Development Facilitation Team (DFT) – Review Comments

Project No: PR-2021-005508 **Date:** 03/06/2024 **Agenda Item:** #1 **Zone Atlas Page:** MX-M

Legal Description: Tract A-1-A-1, Gateway at Paseo del Norte

Application For: PS-2024- 00042 – SKETCH PLAT

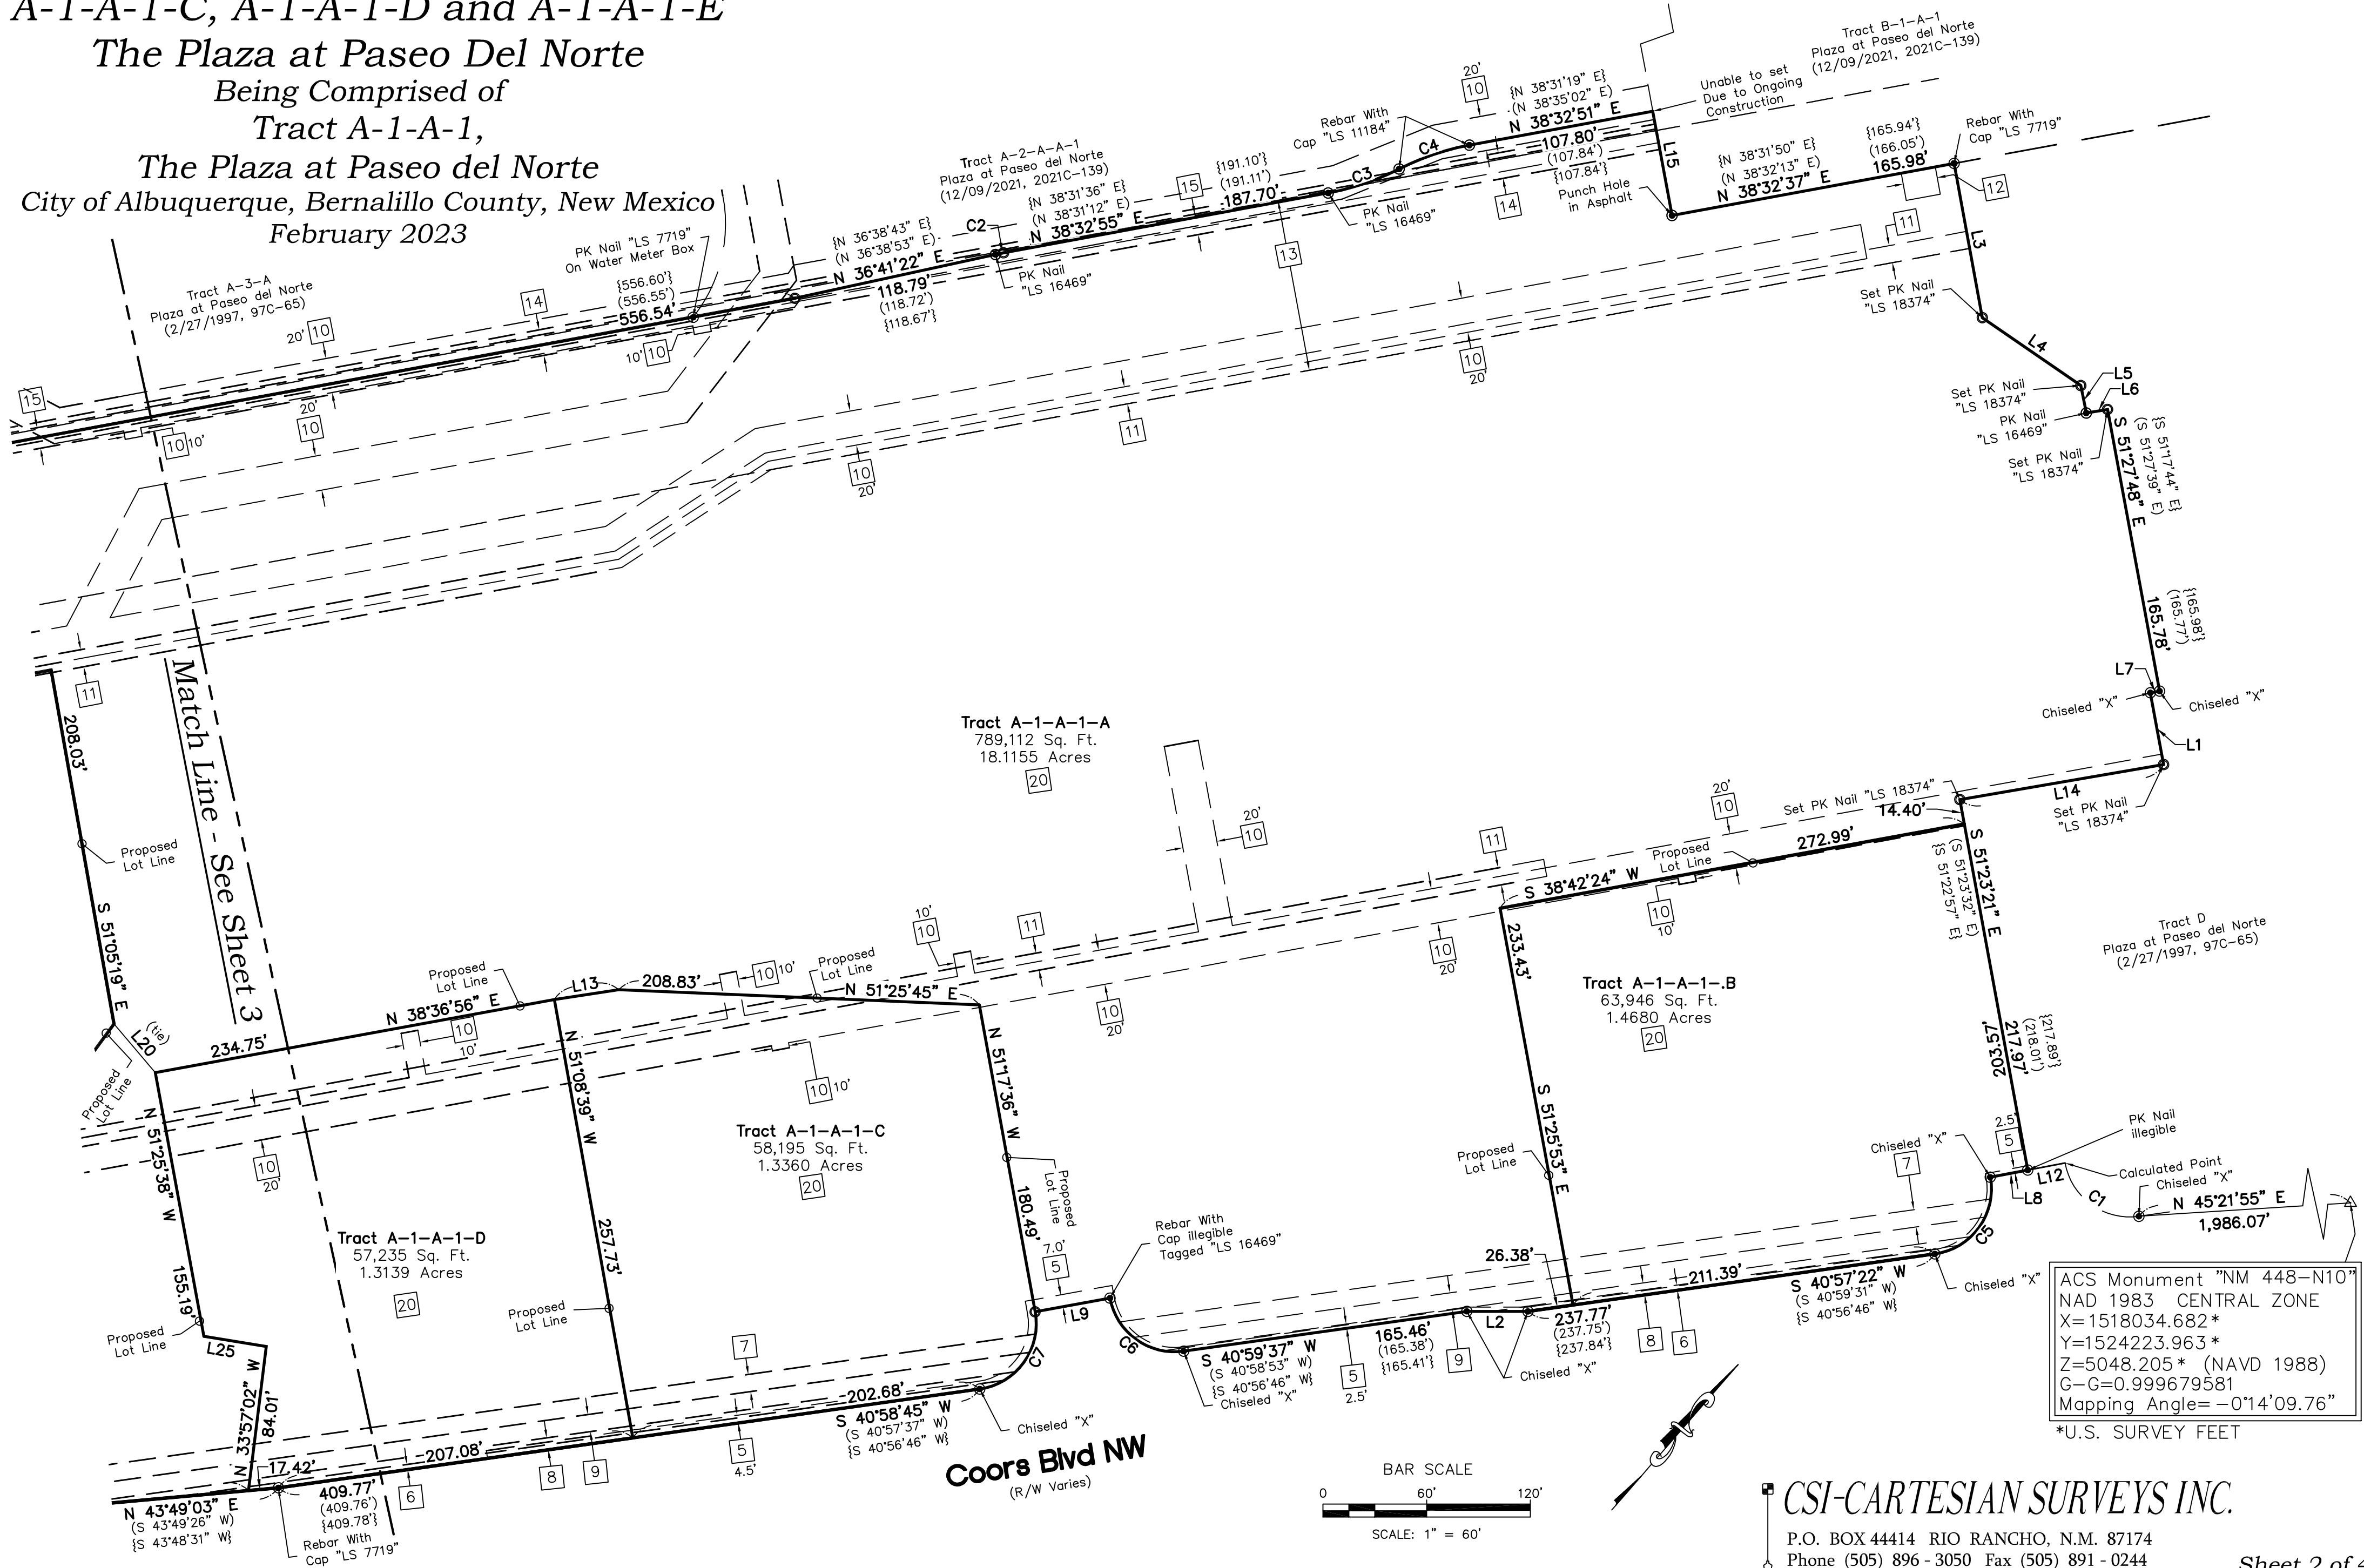
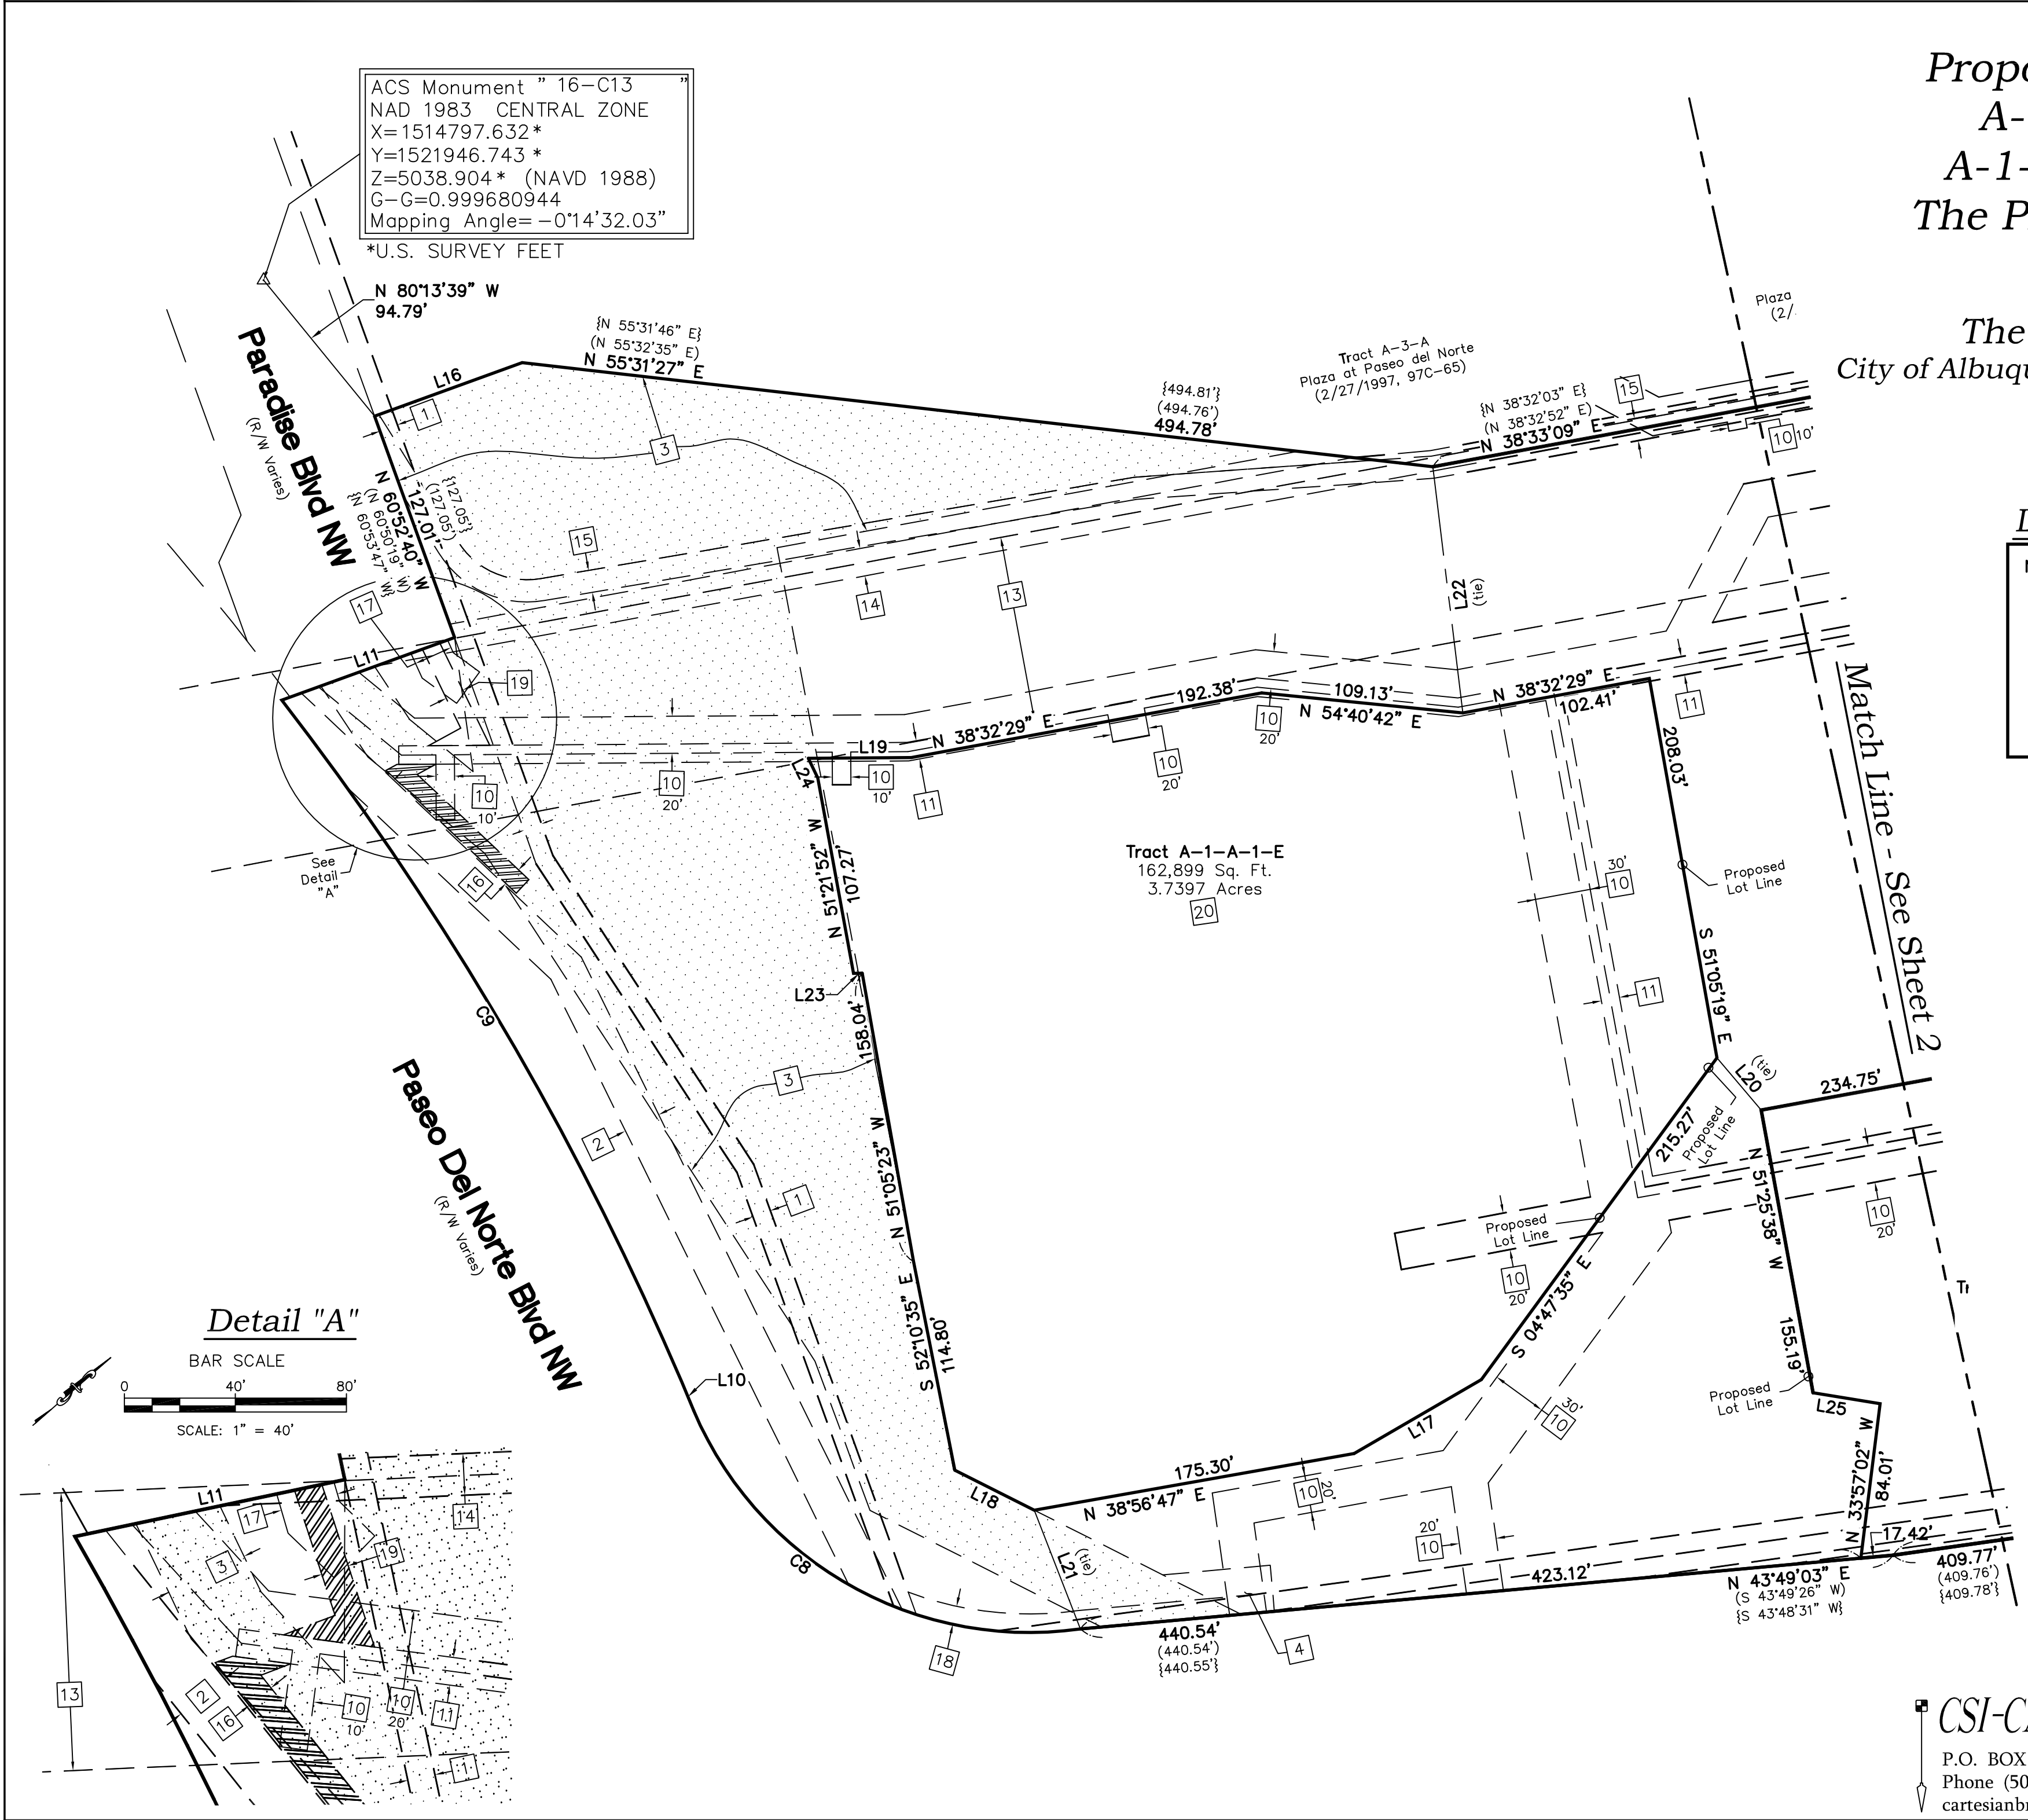
1. Easement #7 is shown as 10' wide. Please provide an additional 10' to provide an adequate corridor for the existing 12-inch sanitary sewer collector line.
